## **Great North Road Solar and Biodiversity Park**

Draft Statement of Common Ground with Nottinghamshire County Council

Document reference – EN010162/APP/8.1

December 2025

Site Access Locations
Figure 14.4 NE
Great North Road Solar and
Biodiversity Park
Environmental Statement

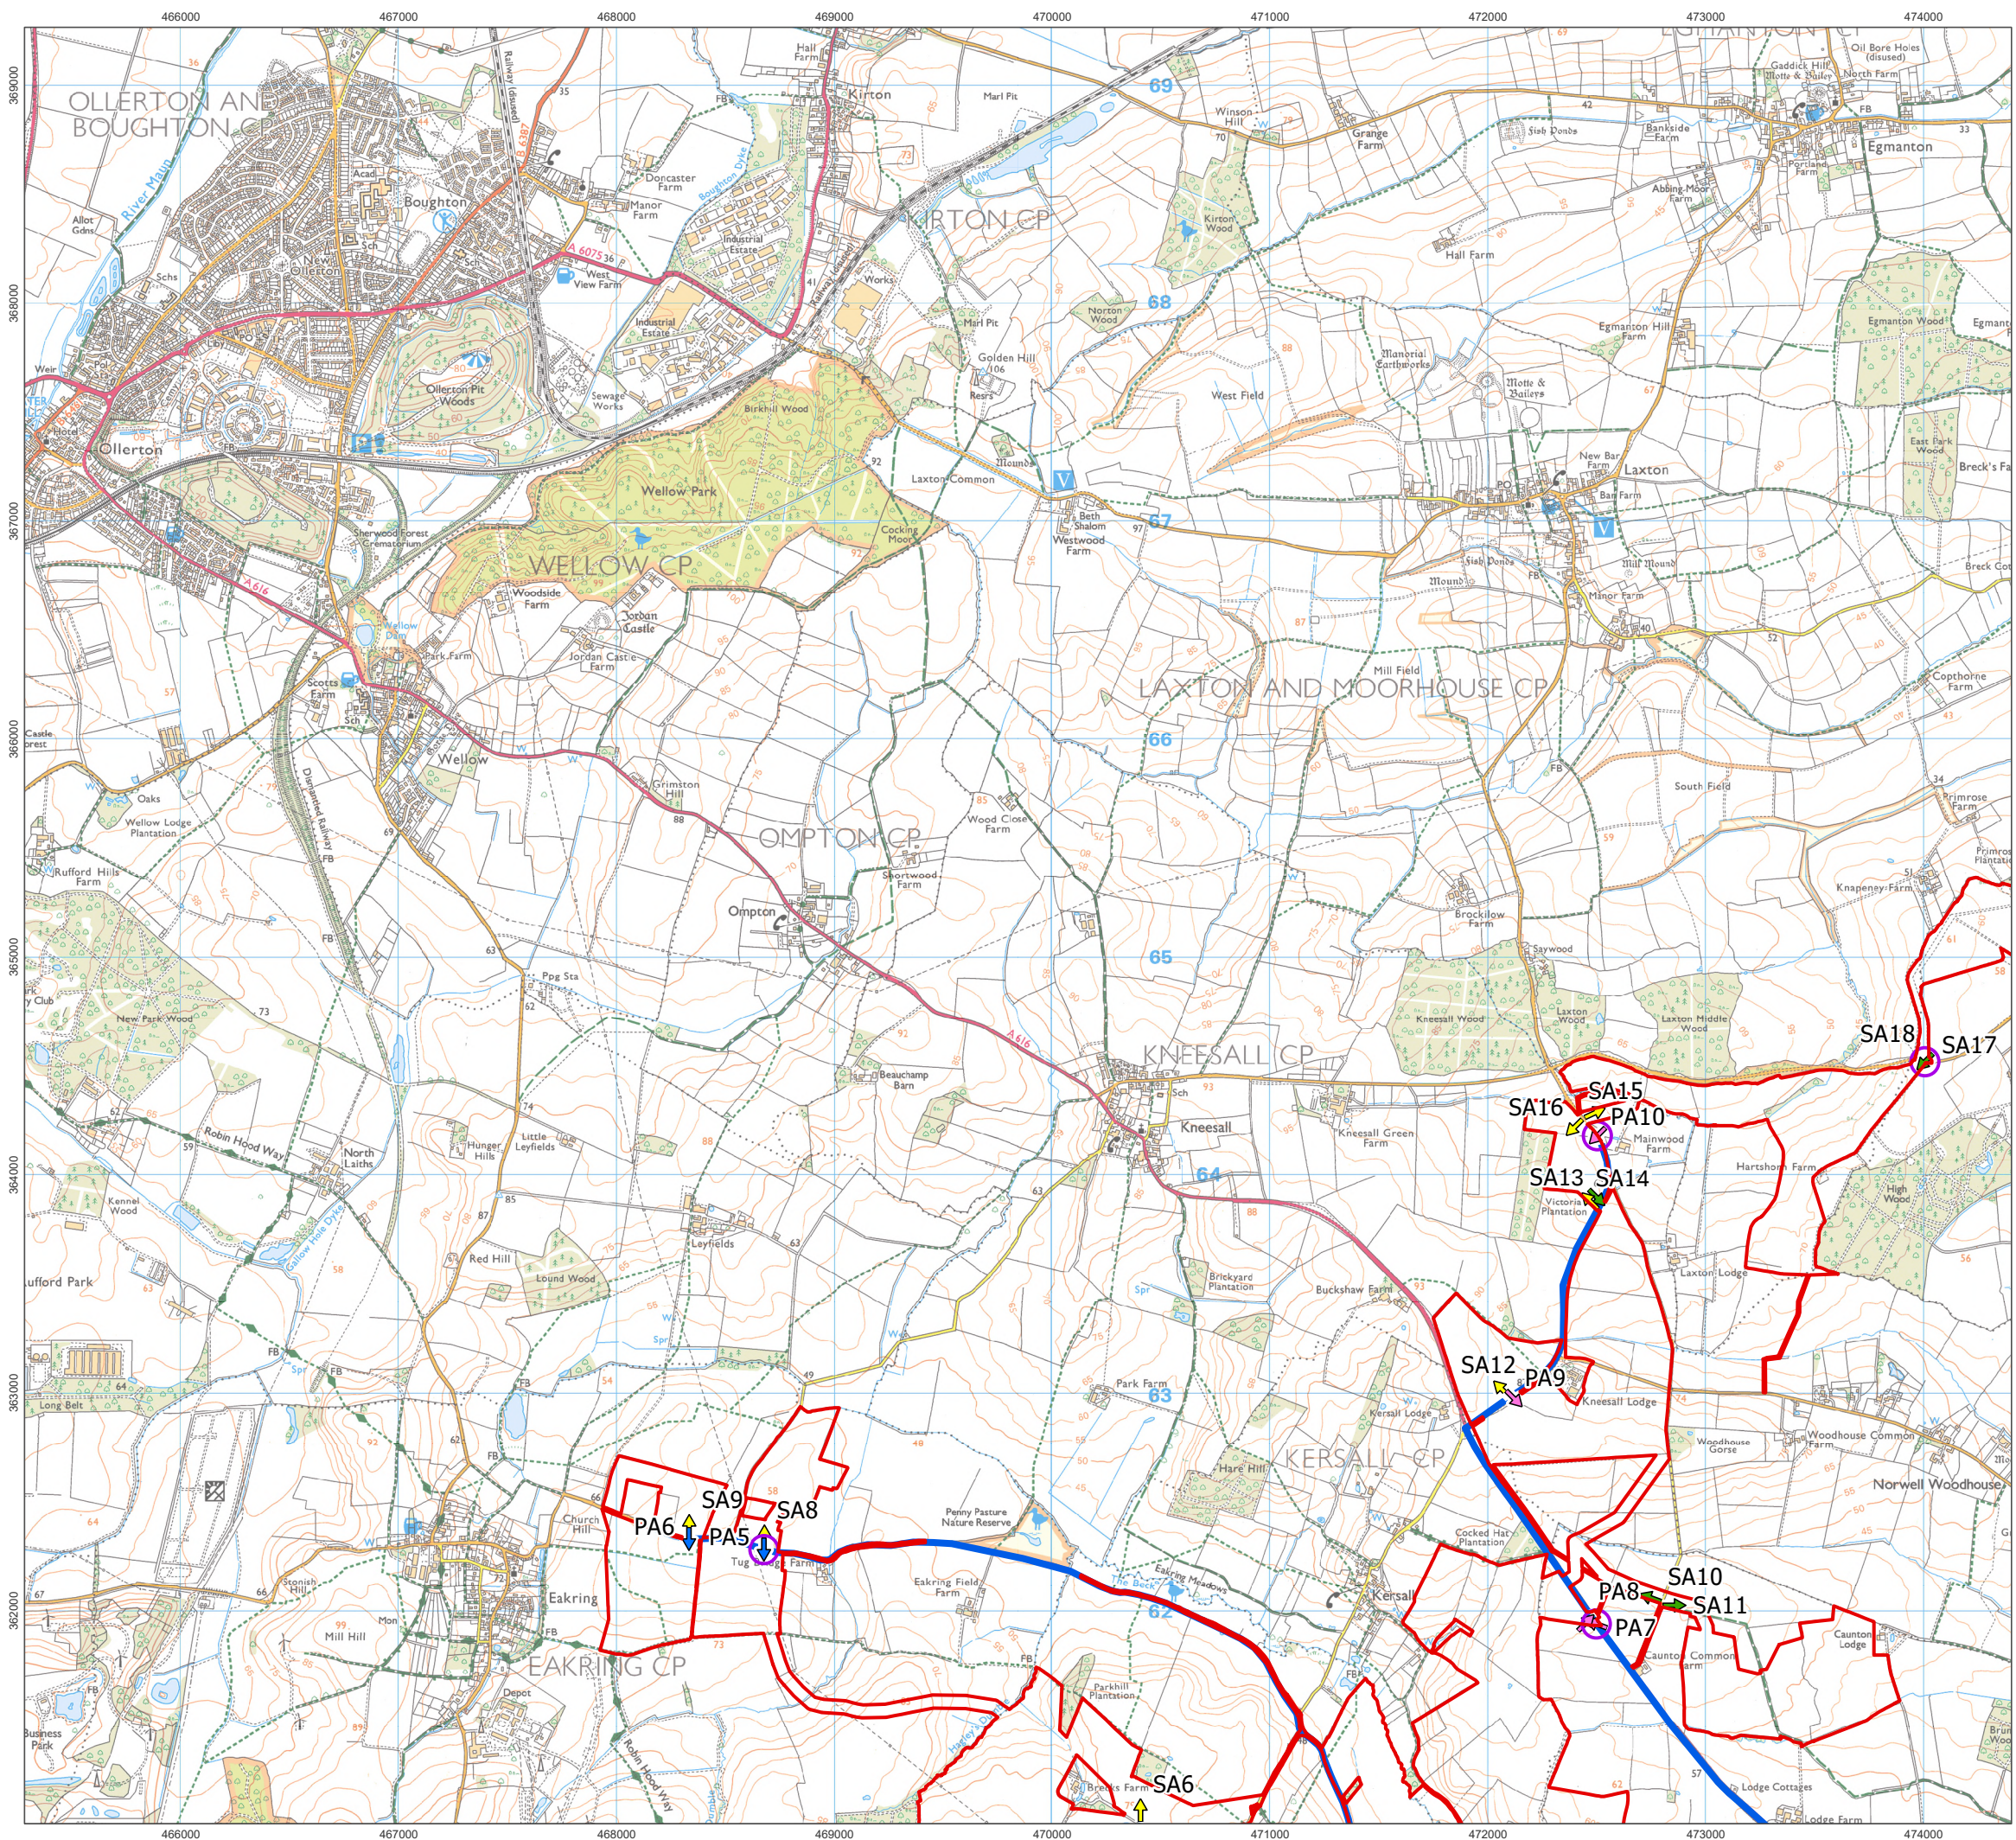
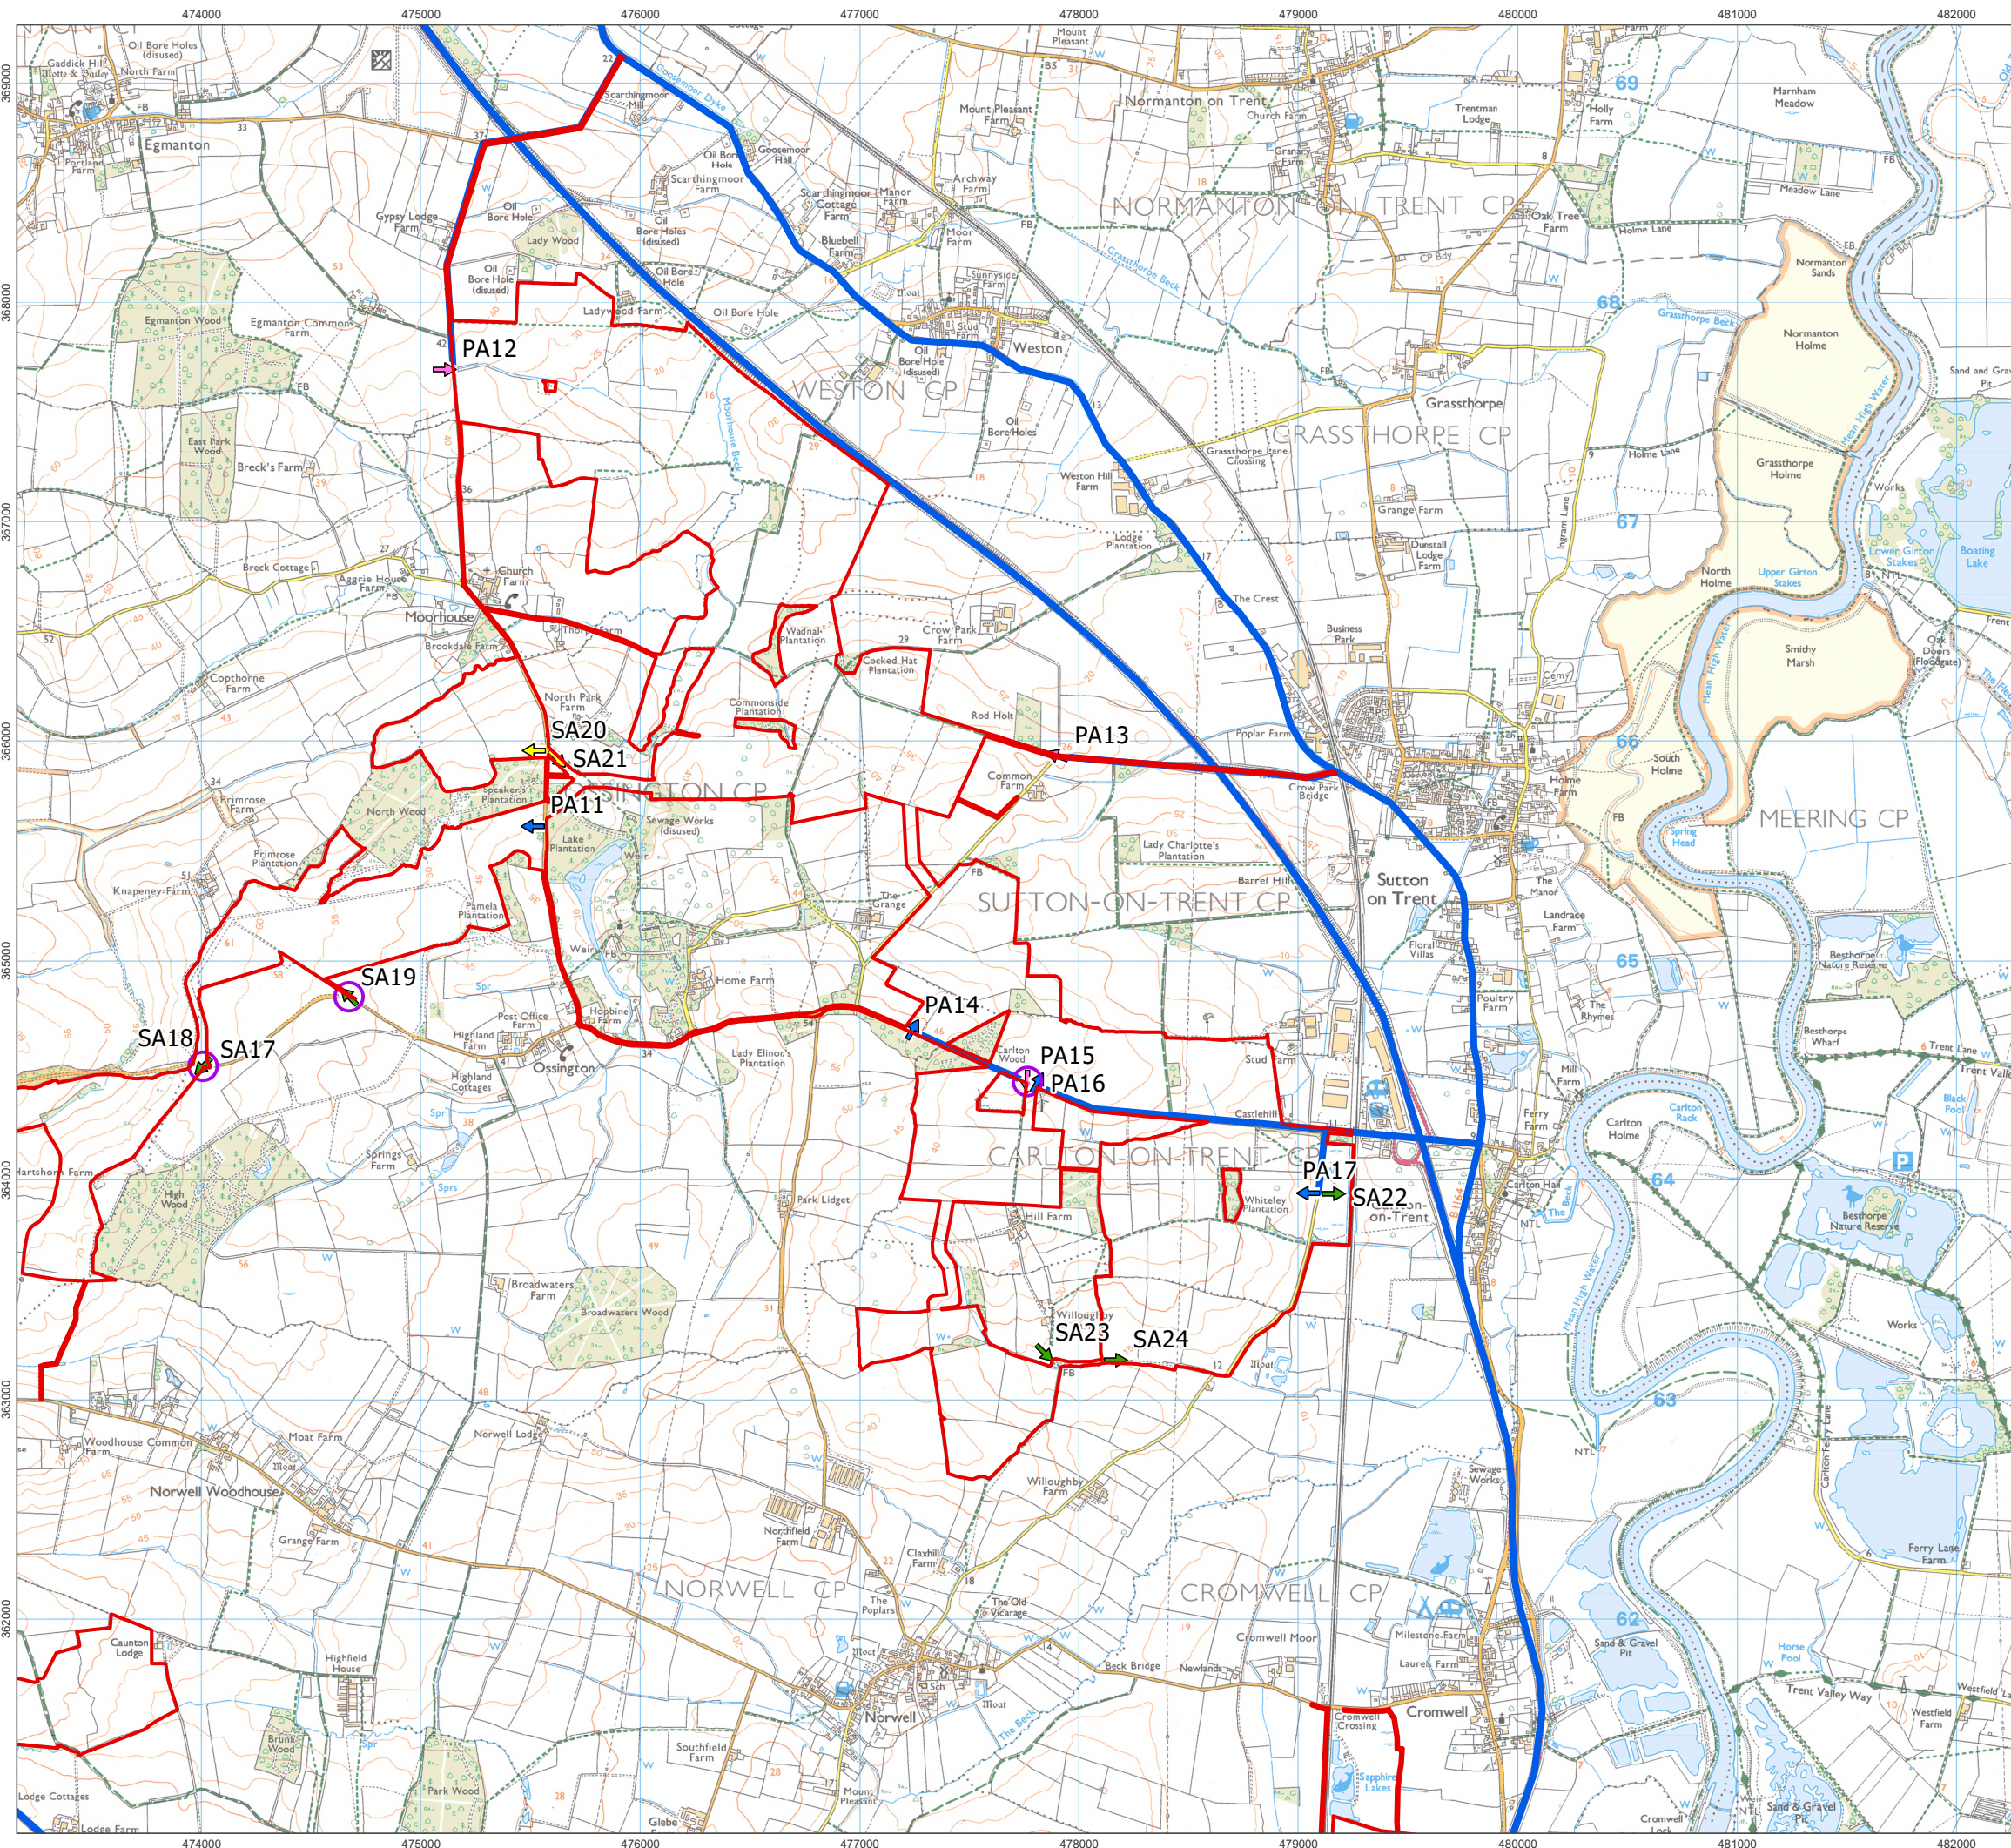
2.5.8	RR	Accesses	<p>The Access Routes Hierarchy is shown in <b>ES Volume 3, Figure 5.1: Works Areas</b> [EN010162/APP/ 6.3.5B]. The</p>	<p>No consideration to the form of access appears to have been given. The traffic information supplied identifies that a number of the accesses trigger the</p>	Under Discussion

Ref	Document Reference	Description of Matter	Applicant's Position	NCC's Position	Status
			<p>Site Access locations are then shown at <b>ES Volume 3, Figure 14.4: Site Access Locations [EN010162/APP/6.3.14A]</b> and <b>ES Volume 3, Figure 14.5: Passing Place Locations [EN010162/APP/6.3.14A]</b>.</p> <p><b>ES Volume 4, Appendix A14.1: Transport Statement [EN010162/APP/6.4.14.1A]</b> Appendix D. provides the site access designs, including their form, key dimensions and demonstrates their suitability through swept path analysis of the largest anticipated HGV entering and exiting each respective location.</p> <p>This analysis of the construction access points confirms that they can be designed to meet relevant design standards.</p> <p>The Applicant will engage with NCC (the Local Highway Authority) to provide any further information, including the</p>	<p>requirement in DMRB CD123 for further assessment, during both the construction and operational phase. Where only occurring in the construction phase, mitigation in the form of traffic management may be acceptable, but locations where this would be required should be identified.</p> <p>Information regarding the number of HGVs at each access was requested, and whilst information in Appendix F provides a breakdown, it is difficult to link the accesses in here to those described elsewhere and therefore clarity is required.</p> <p>Whilst a statement is made that the access drawings are outline drawings and detailed designs will be forthcoming at the appropriate time, the principle of acceptability needs to be established. There are a number of accesses, either proposed or amended (with increased usage) which have</p>

Ref	Document Reference	Description of Matter	Applicant's Position	NCC's Position	Status
			requirements for a Road Safety Audit.	apparent highway safety concerns. All new or amended accesses should therefore be subject to a Stage 1 Road Safety Audit, as required by the Nottinghamshire Highway Design Guide, to inform this process.
